# CITY OF PORTLAND, MAINE

Project Name: **Commercial Development including gas station and convenience store with ATM**  
Project ID: 2013-086 CBL: 237-A-012  
Address: 2282 Congress Street, Portland  
Joint Applicants: C J Developers, Inc. and Portland Property Holdings, LLC  
Planner: Jean Fraser

**From:** Tom Errico <thomas.errico@tylin.com>  
**To:** Jean Fraser <JF@portlandmaine.gov>  
**CC:** David Margolis-Pineo <DMP@portlandmaine.gov>, Jeff Tarling <JST@portlandmaine.gov>, Katherine Earley <KAS@portlandmaine.gov>, Jeremiah Bartlett <JBartlett@portlandmaine.gov>  
**Date:** 5/9/2013 11:23 AM  
**Subject:** 2282 Congress Street - Final Traffic Comments

# PLANNING BOARD REPORT

SHEET TITLE  
**GENERAL IMPROVEMENTS  
PLAN AND PROFILE**

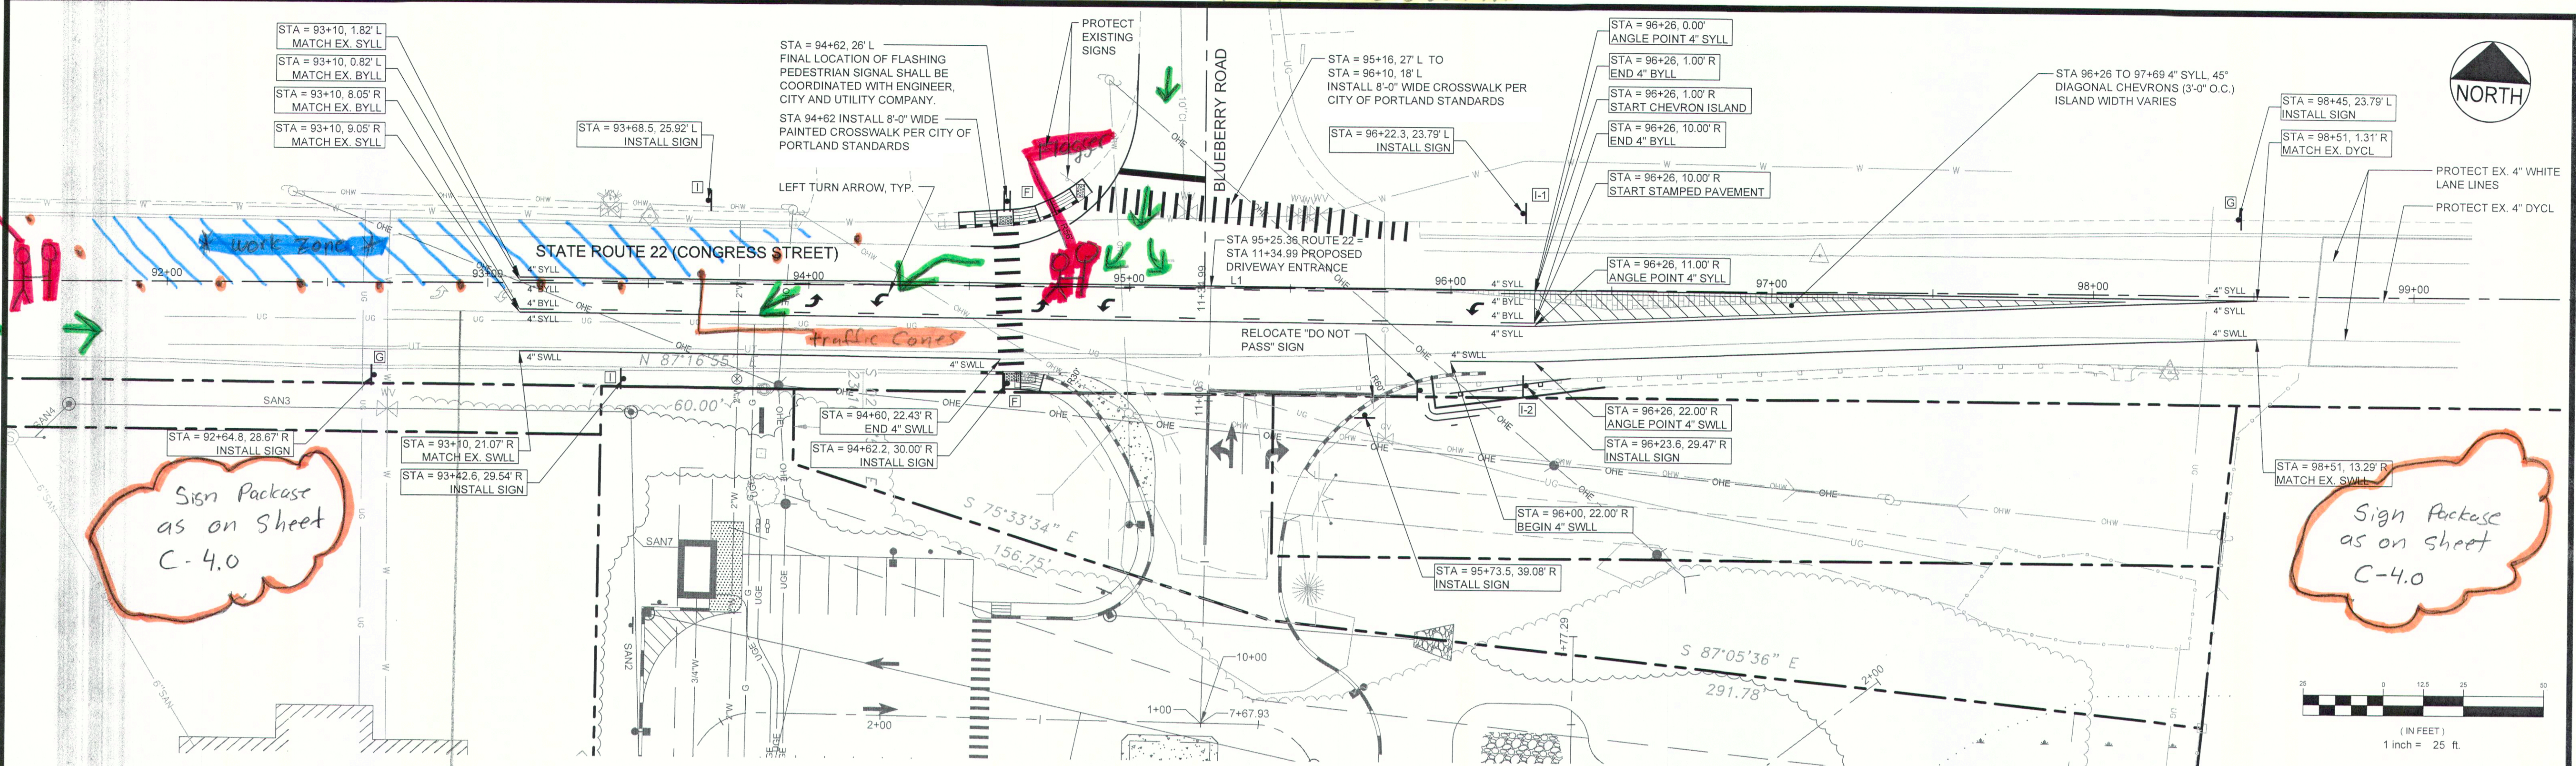
- The applicant has developed an improvement plan for Congress Street such that left-turn accommodations are provided. I support the general concept of the plan provided in the application. Final design plans shall be submitted to the City for review and approval (It should be noted that adjustments to the design may be required during this review process).

- A pedestrian crosswalk is being proposed on Congress Street between the project site and Blueberry Road. Through the contract rezone process the crosswalk was to include a refuge median island in addition to a flashing sign warning system. Given vehicle turning needs, a refuge island is not feasible at this location. In lieu of the refuge island the applicant shall construction an ADA accessible landing on the northwest radius of Blueberry Road. In addition, the crosswalk pavement marking shall consist of durable paint. Final design elements shall be reviewed and approved by the City.

- iv. That the applicant shall submit a revised off-site improvements plan that addresses Tom Errico's memorandum dated 05.09.2013 regarding the left turn accommodations, crosswalk design with ADA landing, and painted crosswalk on Blueberry, for review and approval by the Planning Authority prior to the issuance of a building permit; and

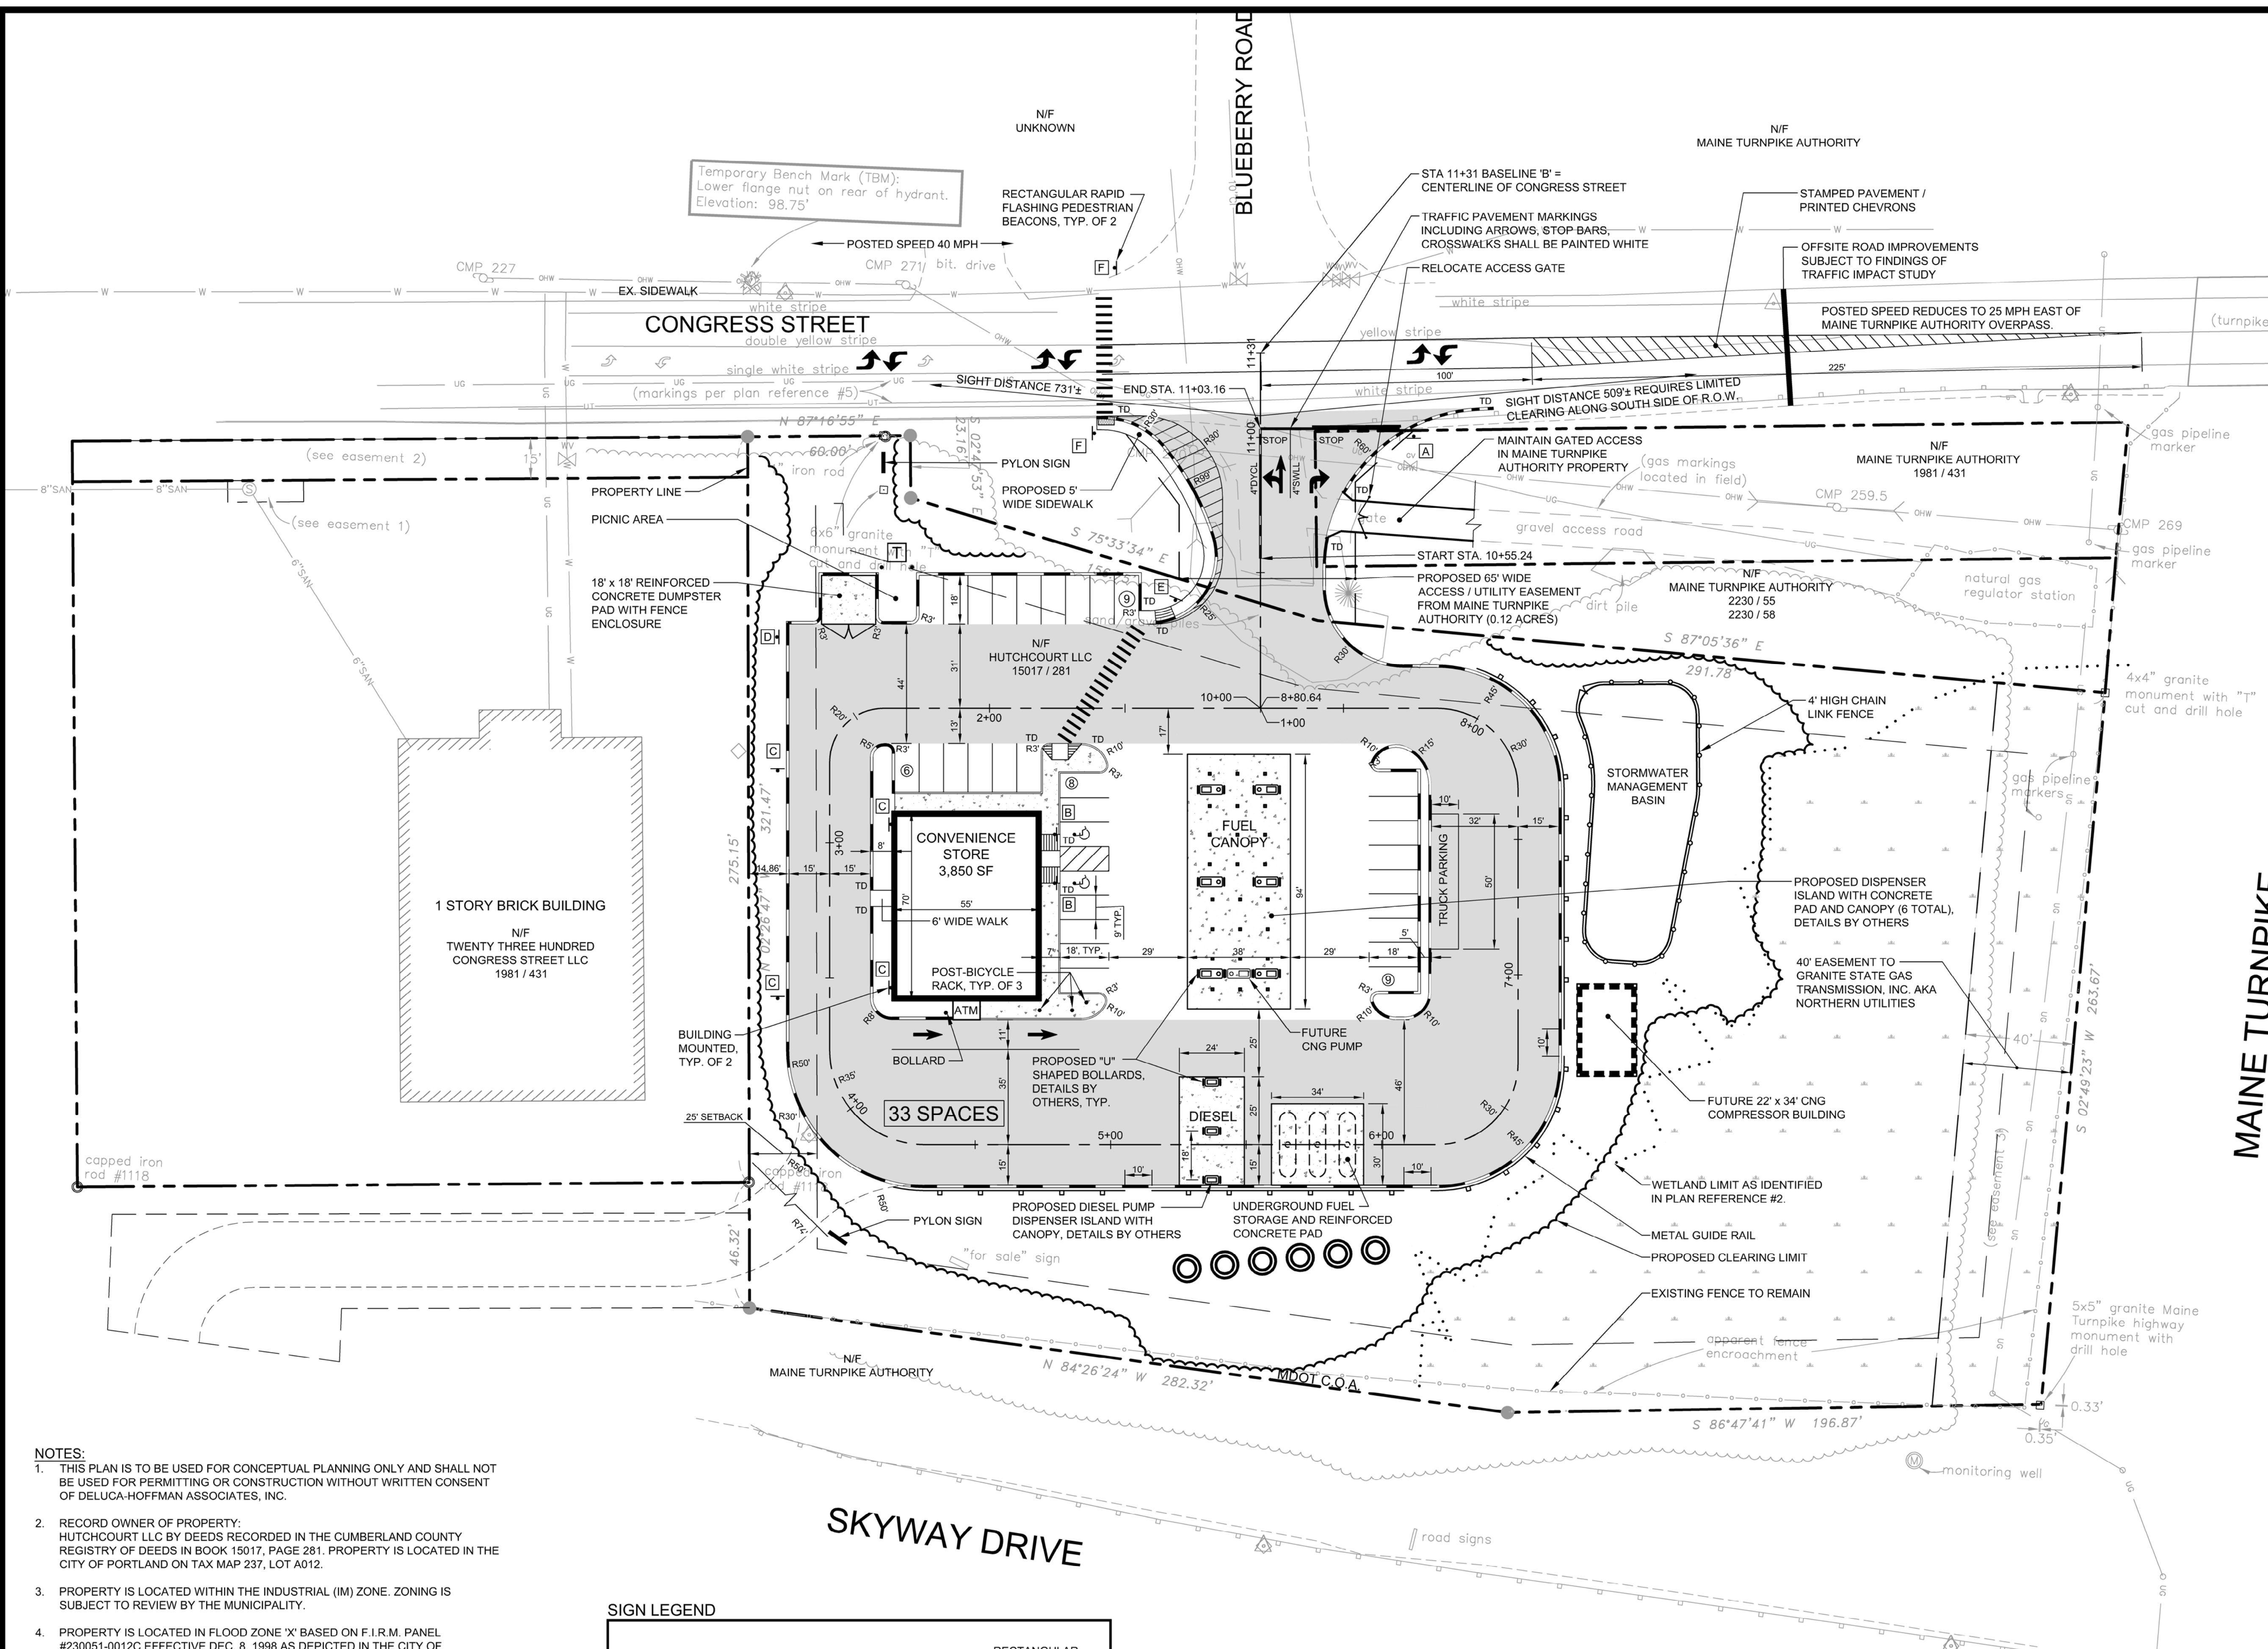
- It is suggested that the pedestrian facility between Congress Street and the proposed convenience store building be as direct as possible. This may require the loss of some of the 9 parking spaces located along the front of the property.

- Parking supply seems excessive for the type and scale of the proposed land use. Supporting documentation on the parking needs shall be provided.  
**Status: The applicant has revised the site plan and is now proposing to construct 26 parking spaces with an option for future expansion of the parking supply if deemed necessary. I find the proposed condition to be acceptable.**

- Auto-turn analyses shall be provided that supports on-site circulation aisle widths and the width of the driveway entrance on Congress Street. The applicant should also provide information on the number of large trucks anticipated to enter and exit the site.

- It is unclear whether there are vehicle circulation restrictions on site (e.g. one-way vs. two-way). Signage and pavements markings shall clearly support proposed circulation restrictions.

- Many aisle widths exceed City standards and waivers from our technical standards may be necessary. As noted above, supporting information will be required before I render any decision on waivers.

**Status: The applicant has revised the site plan to improve the crosswalk alignment and given constraints with Maine Turnpike Authority property, I find the proposed condition to be acceptable.**

**Status: The site plan has been revised based upon discussions with the applicant and I find the proposed plan to be acceptable. I would note that the applicant did add a raised concrete apron at the driveway entrance and I find this condition to be acceptable. A waiver for driveway width is required and given large truck turning requirements, I support a waiver from City standards.**

**Status: It is my understanding that the revised site plan accounts for a one-way circulation around the back side of the convenience store. Signage and pavement markings should be provided.**

**Status: Given the specific needs of on-site vehicle circulation and accessibility to fueling areas, I find the proposed layout to be acceptable and support waivers from City standards.**
